Submission for Job: #6010 SSD 6010 - One Residential Building (Student Accommodation) within Darling Drive Plot

SSD 6010 - One Residential Building (Student Accommodation) within Darling Drive Plot

Submission by:

29 July 2013

SHADOW DIAGRAMS: PERSPECTIVE, SHOWING THE PEAK, WINTER SOLSTICE

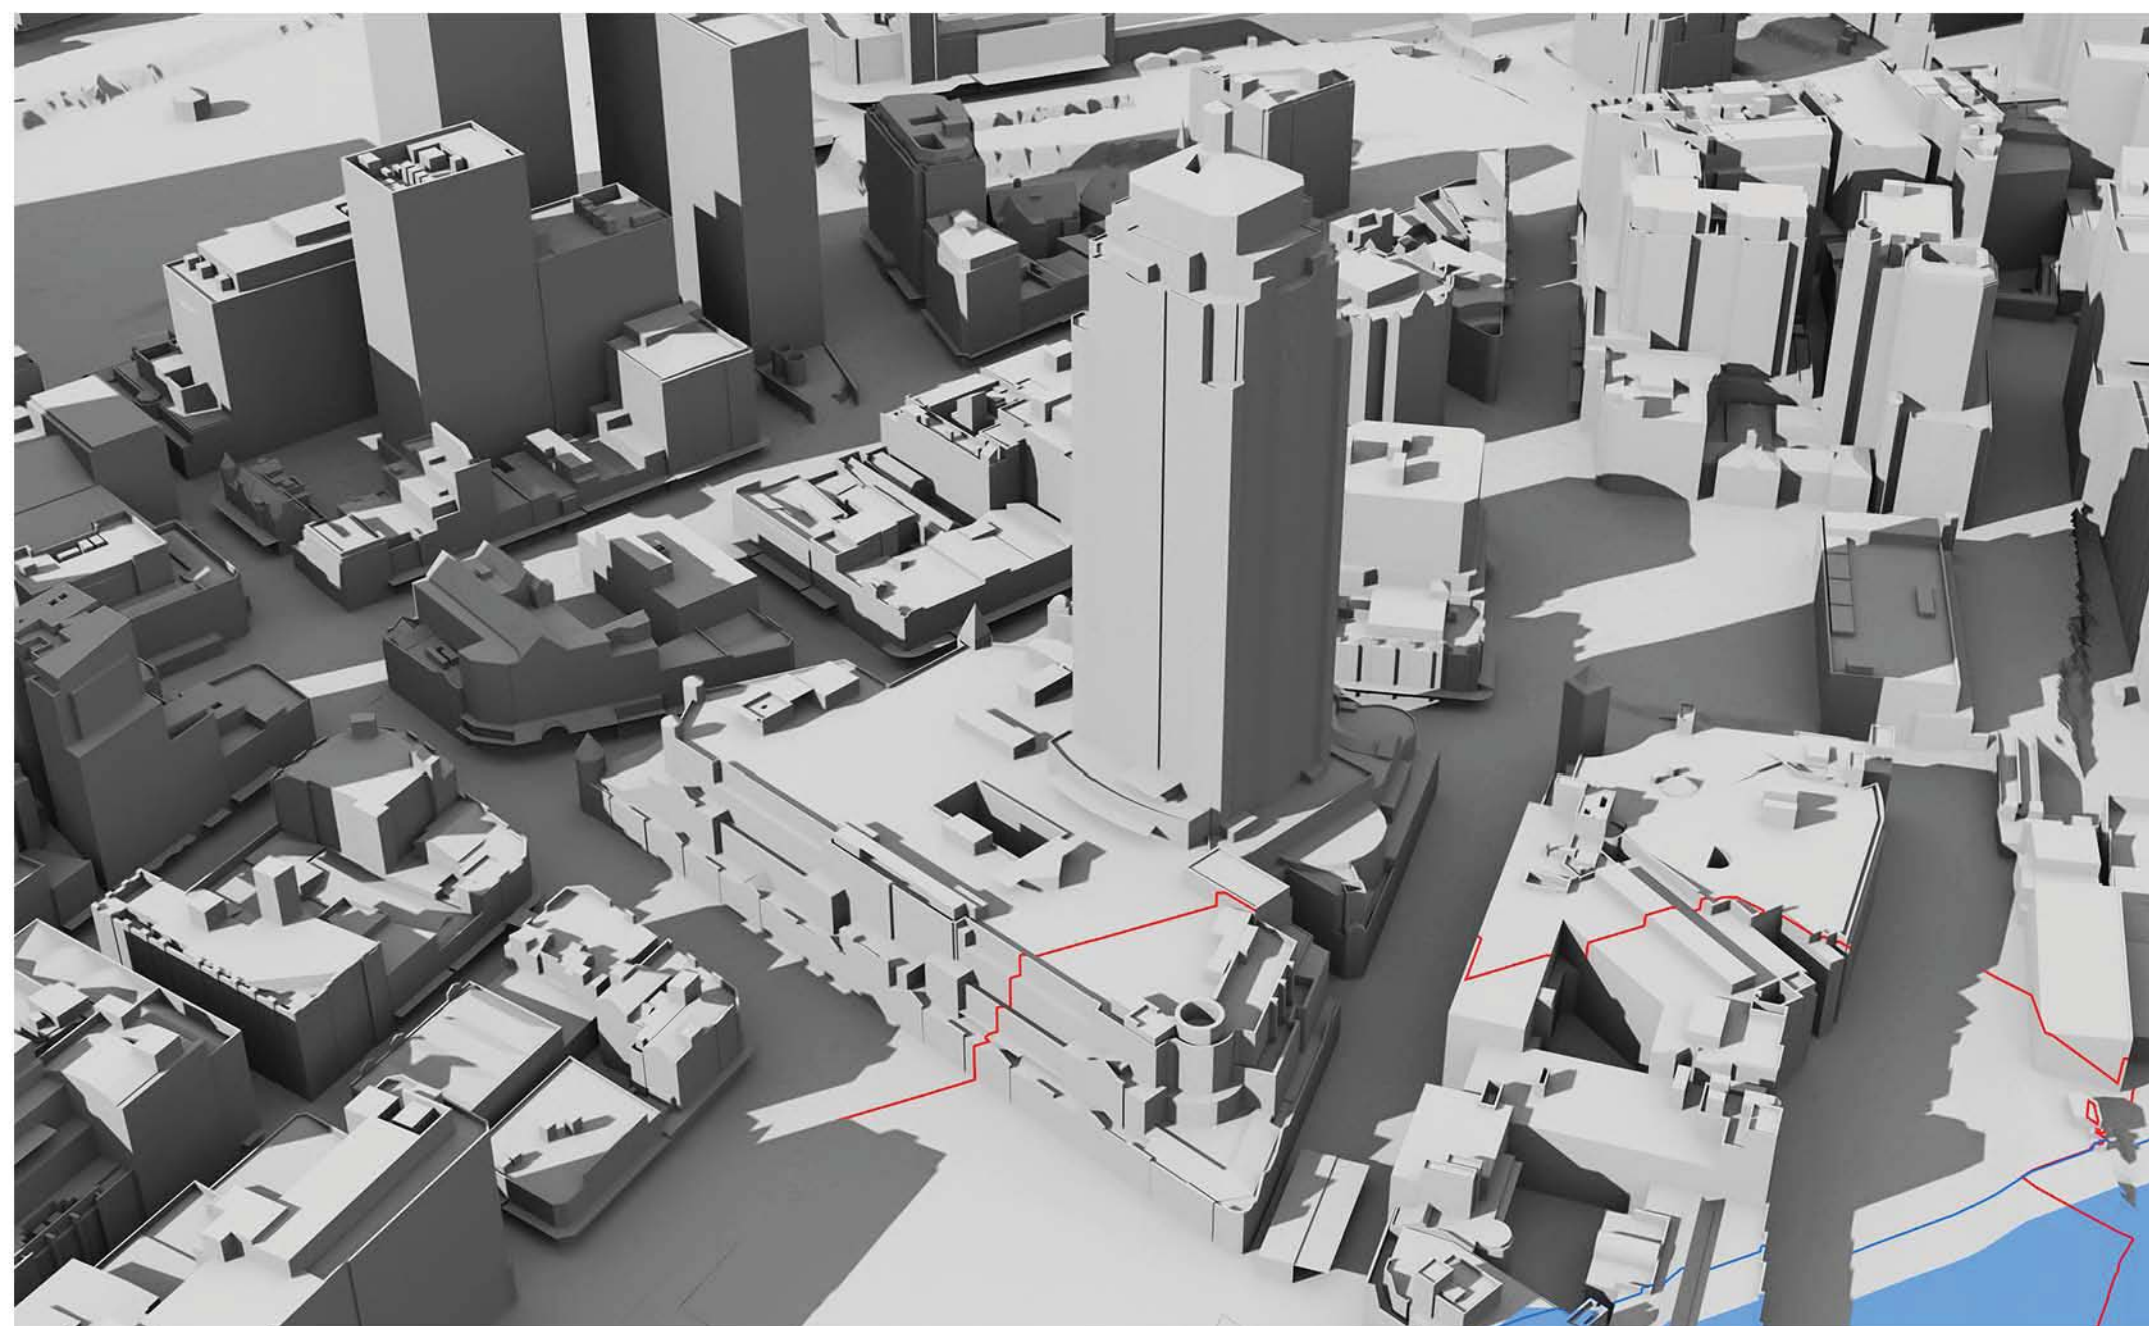
6. Existing shadowing of the west façade of The Peak on 21 June

We refer to the shadow diagrams in SSD5878, Appendix H. Supplementary Design Report, Section 6. Amendments, Winter solstice - 22 June. This is not 21 June, but there would be no noticeable difference.

At 9am, 10am and 11am the west façade is totally in shadow due to other parts of The Peak building itself.

At 12pm there is still substantial existing shadowing on the west façade caused by the irregular shape of the west facade.

At 1pm the existing shadowing has been substantially removed, but not totally removed.

It can be concluded that some single aspect apartments on the west façade and some south-west dual aspect corner apartments currently receive less than 2 hours direct sunlight to habitable rooms and 50% of the private open space between 9am and 3pm on 21 June.

By 2pm the existing shadowing has been totally removed, but that is too late to achieve two hours of direct sunlight before 3pm.

At 9am, 10am and 11am the west façade is totally in shadow due to other parts of The Peak building itself.

At 12pm there is still substantial existing shadowing on the west façade caused by the irregular shape of the west facade.

At 1pm the existing shadowing has been substantially, although not entirely, removed. However, overshadowing of lower levels of the west façade by the concept proposal parameter plan shadows for the N,NE and SE plots has already started.

By 2pm the existing shadowing has been totally removed. However, overshadowing of the west façade by the SSDA4 and SSDA5 buildings has appeared and risen further up the west façade than the concept proposal parameter plan shadows for the N,NE and SE plots, which is still present.

At 3pm, the proponent states correctly that 45-45% of the western façade is overshadowed by the SSDA4 and SSDA5 buildings.

It can be concluded that, as a result of combination of the proposed development with existing shadowing of the west façade, some single aspect apartments on the west façade and the south-west dual aspect corner apartments which currently receive less than 2 hours direct sunlight to habitable rooms and 50% of the private open space between 9am and 3pm on 21 June will suffer additional overshadowing. It is beyond our skills to count the number of such apartments. We note that the proponent has made no attempt to do so.

Rather than counting the number of units which will not meet the DCP guidelines, the proponent attempts to trade-off direct sunlight at 4pm for lack of direct sunlight during the period 9am to 3pm. There is no provision in the DCP guidelines for such a trade-off.
